2nd November 2020

Application No: EP/115/20/PL
Site Address: 4 Beechlands Close & land rear of 18 Montpelier Road East Preston BN16 1JZ
Description of works: Side extension, loft conversion & detached garage to existing dwelling & erection of 2 No semi detached houses. This site is in CIL Zone 4 & is CIL Liable as new dwellings.

The Planning & Licensing Committee of this committee considered this Application at its meeting on Monday, 26th October.

FRONT ELEVATION EAST

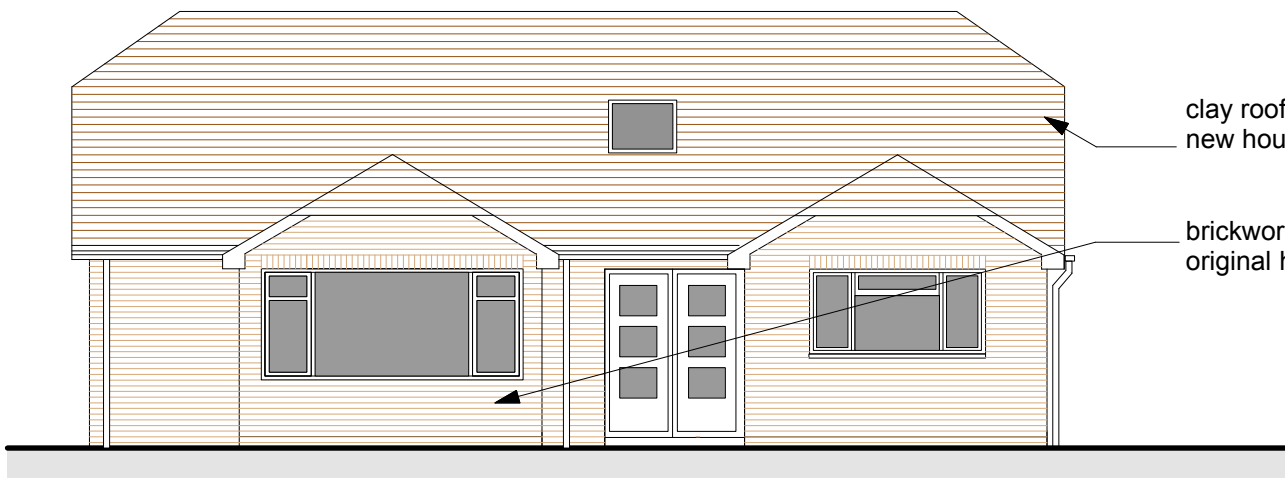
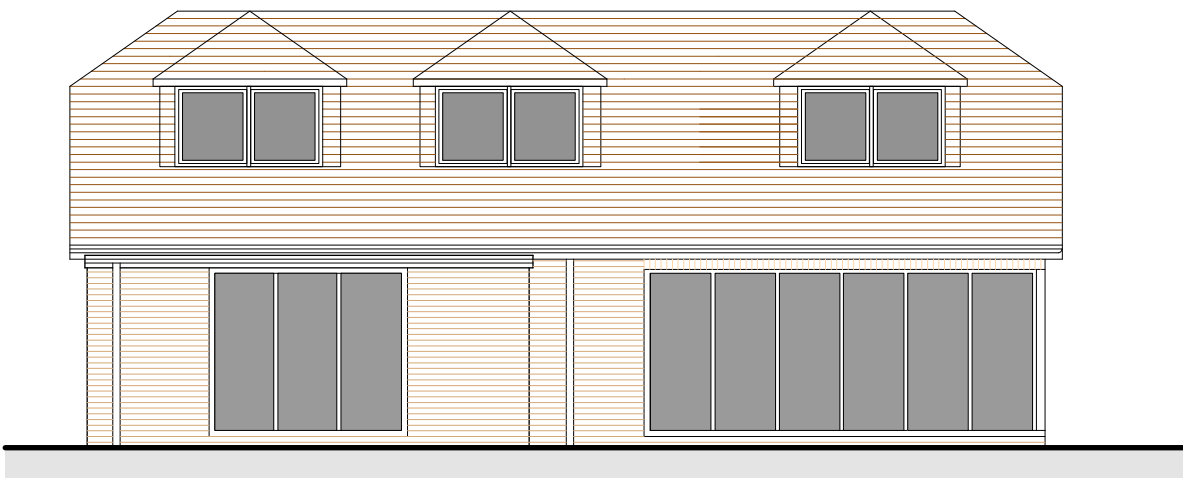
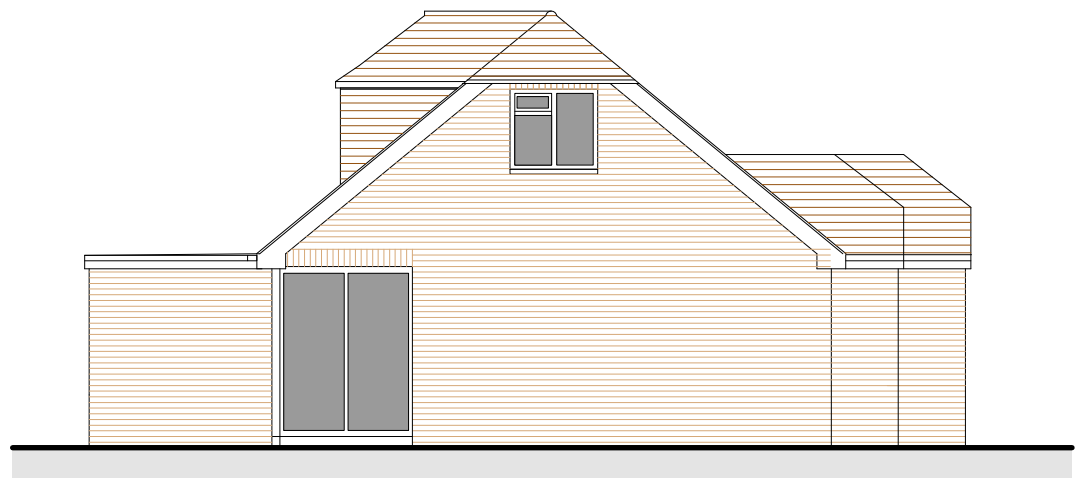
The proposed redevelopment of 4 Beechlands Close will again be an overdevelopment of the plot. The existing property is a well-balanced, neat property in keeping with the other single-storey properties at that end of Beechlands Close. The proposed redevelopment will result in a property this council feels would be too large for the plot and the area. The design of the redeveloped property feels unduly heavy, out-of-character with neighbouring bungalows. We do not believe there are any similar barn-style properties in this part of the

village. We do not believe any other properties at the northern end of Beechlands Close has a front-facing rooflight. We would be concerned the rear-facing dormer windows would overlook the private amenity of neighbouring properties resulting in a loss of privacy.

The site is in Character Area Two of the East Preston Neighbourhood Plan. All three storeys have a proposed first floor which is contrary to Policy 3i which states maintain a consistent low building height, with no development proposal of more than 1.5 storeys. The Policy continues, ii. where new rooms are to be created in a roof space, ensure the height of the roof is not increased and the basic form of the roof is not altered this proposal is clearly contrary to that.

DOUBLE GARAGE PLAN

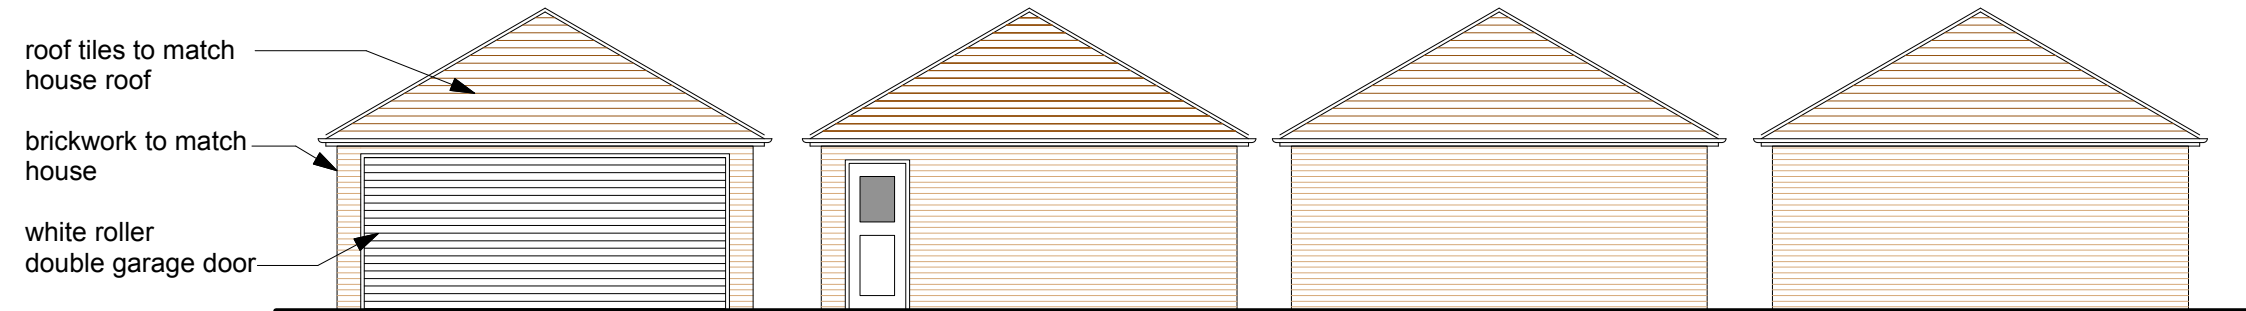
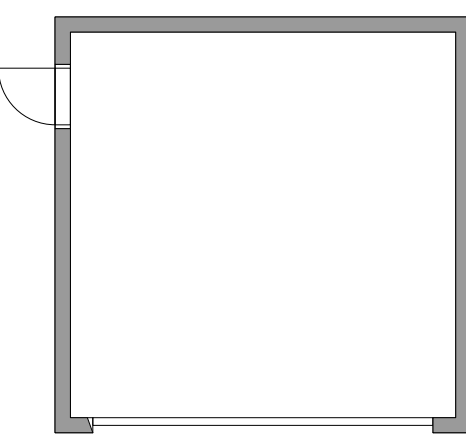
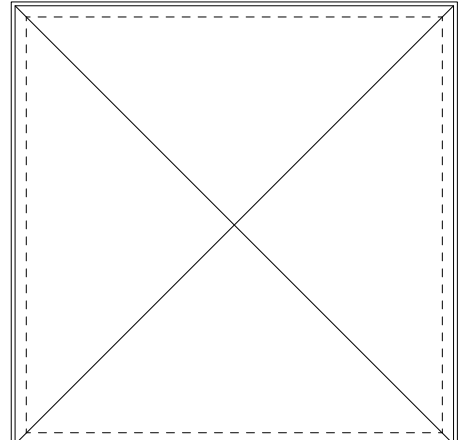
The council wholly objects to the proposal to position a sizeable garage in the front garden of the property. Not only is this much larger than the existing garage it will also be much further forward and therefore it will possibly be the most visible feature of the property.

18 BEECHLANDS COURT, EAST PRESTON, BN16 1JZ	
Client	Description
c/o RSP ARCHITECTS LTD	NEW SEMI-DETACHED HOUSE PLANS AND ELEVATIONS

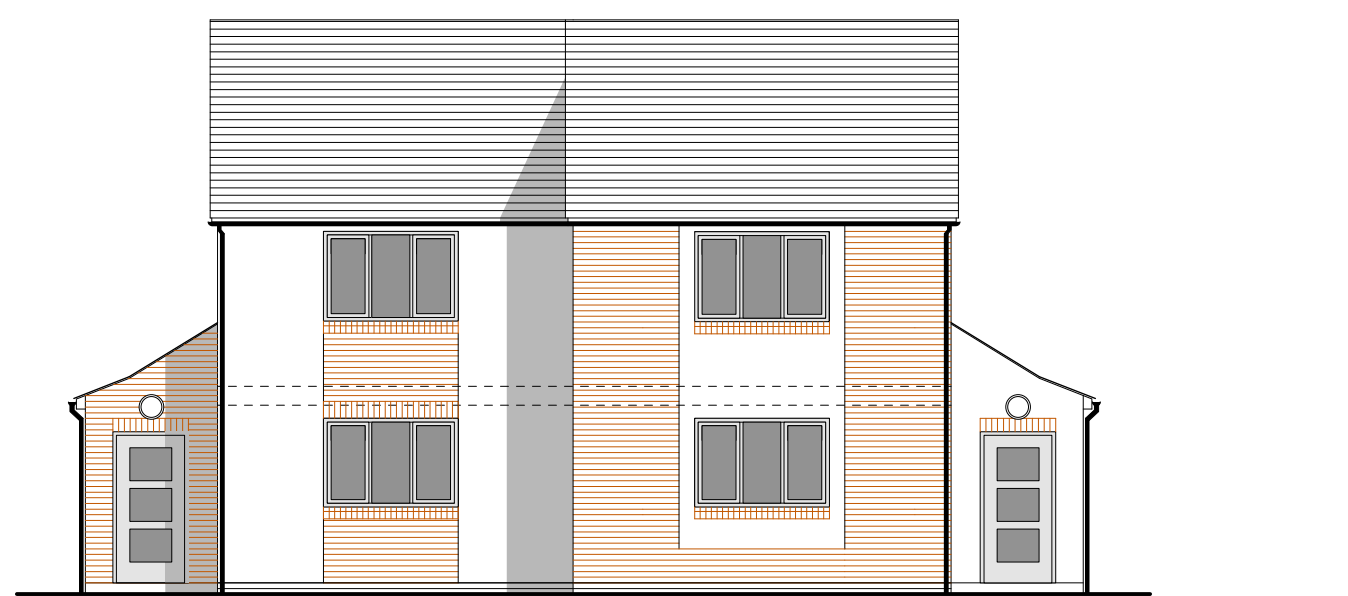
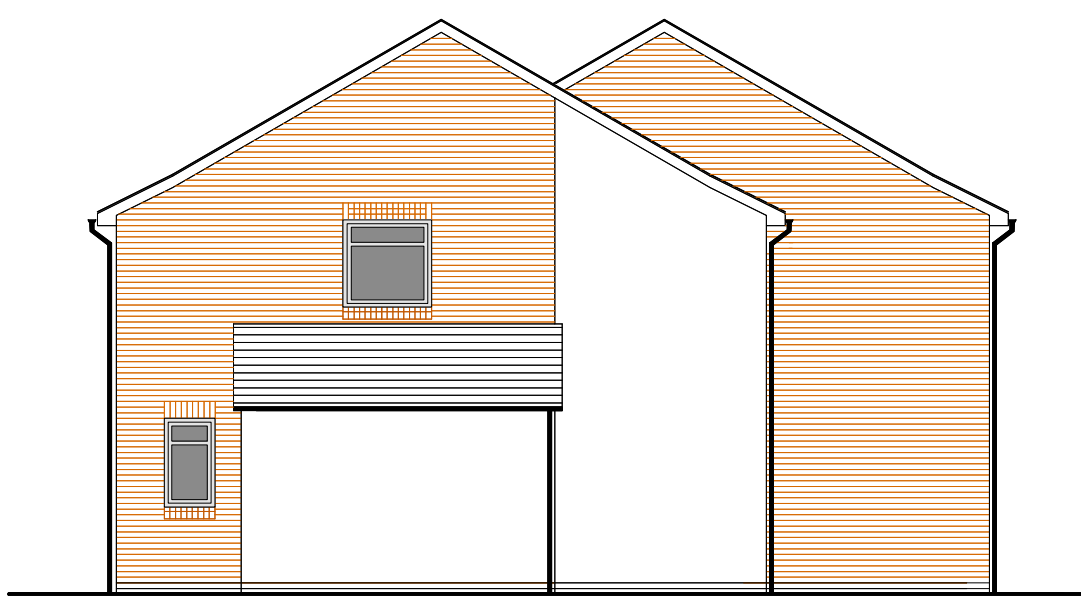
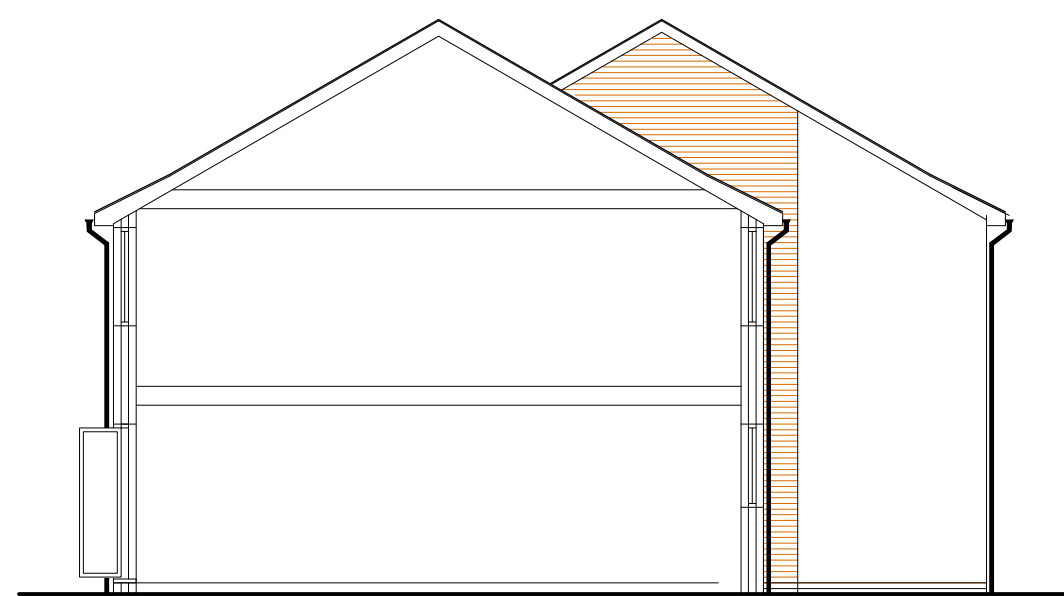
Starting with the two new houses to be built. The committee was concerned at the lack of amenity space with these two properties. Members believed the resulting properties would appear very cramped on the site and would be out-of-keeping with the streetscene and the general spatial character of the area. Directly opposite the plot, the flats have attractive front gardens which enhance the area. Two properties on this plot, even with off-street parking provided, will lead to an increased demand for parking space in an already congested part of the village. We believe two properties on this plot will be overdevelopment.
